KITTITAS COUNTY

MEMORANDUM

TO: All Staff
FROM: Public Works Plan Review Team
DATE: September 5, 2025
SUBJECT: BL-25-00010 Folden

**RECORD OF SURVEY**  
 A PORTION OF THE SW 1/4 OF SECTION 16,  
 TOWNSHIP 21 NORTH, RANGE 14 EAST, W.M., KITTITAS COUNTY, WASHINGTON

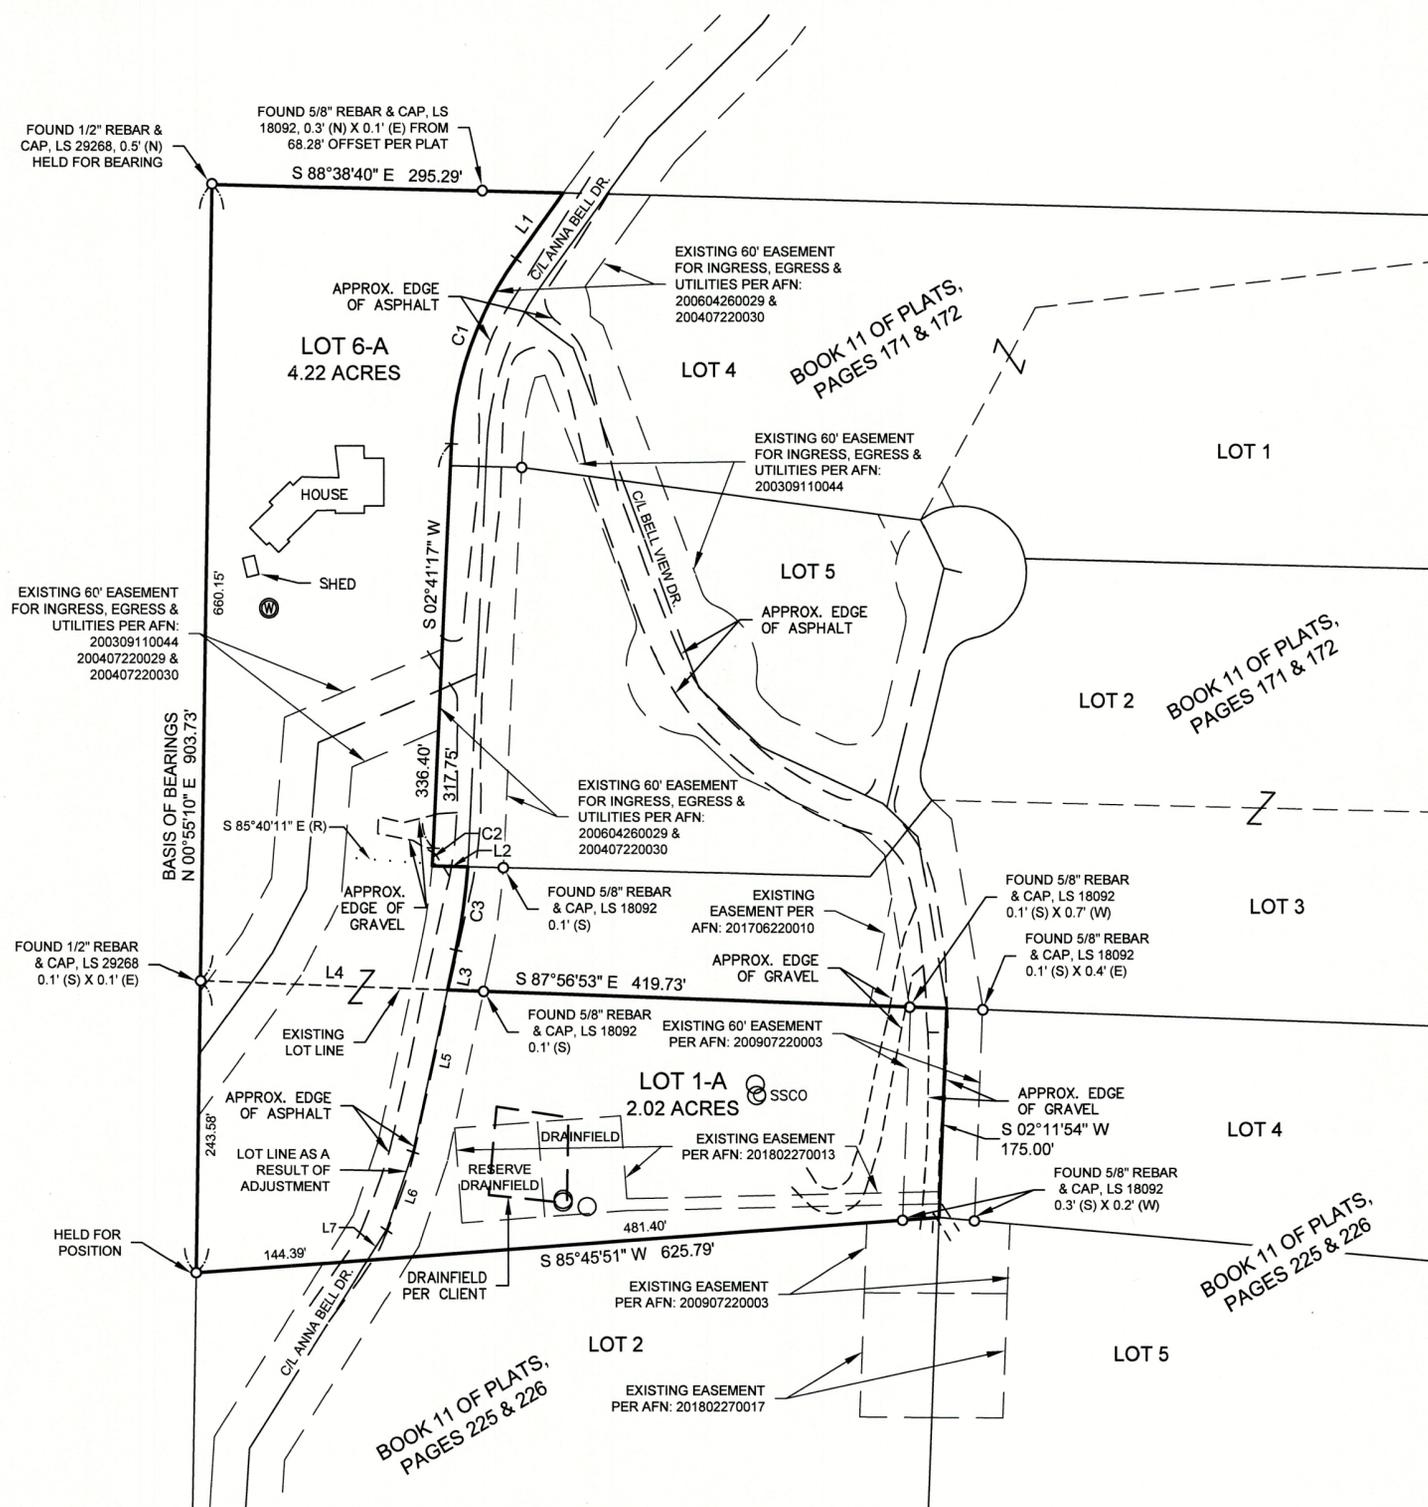
<p>SURVEY</p>	<ol style="list-style-type: none"> 1. As a minimum, the new lot line should have corners set and shown on the face of the map or a note stating why this was not done. <p>Of Note</p> <ol style="list-style-type: none"> 1. There are multiple property corners shown that are not tied into the survey. If any of them were utilized as survey control, they should include bearings and distances to tie their position to the survey. 2. There are multiple corners that include distances from calc position to found position. The majority of these corners cannot be calculated from the data shown on the map, and would require additional documents to calculate. If a corner is shown as not matching the calculated position, it would make sense to include suitable data to calculate the position from the map. (JT)
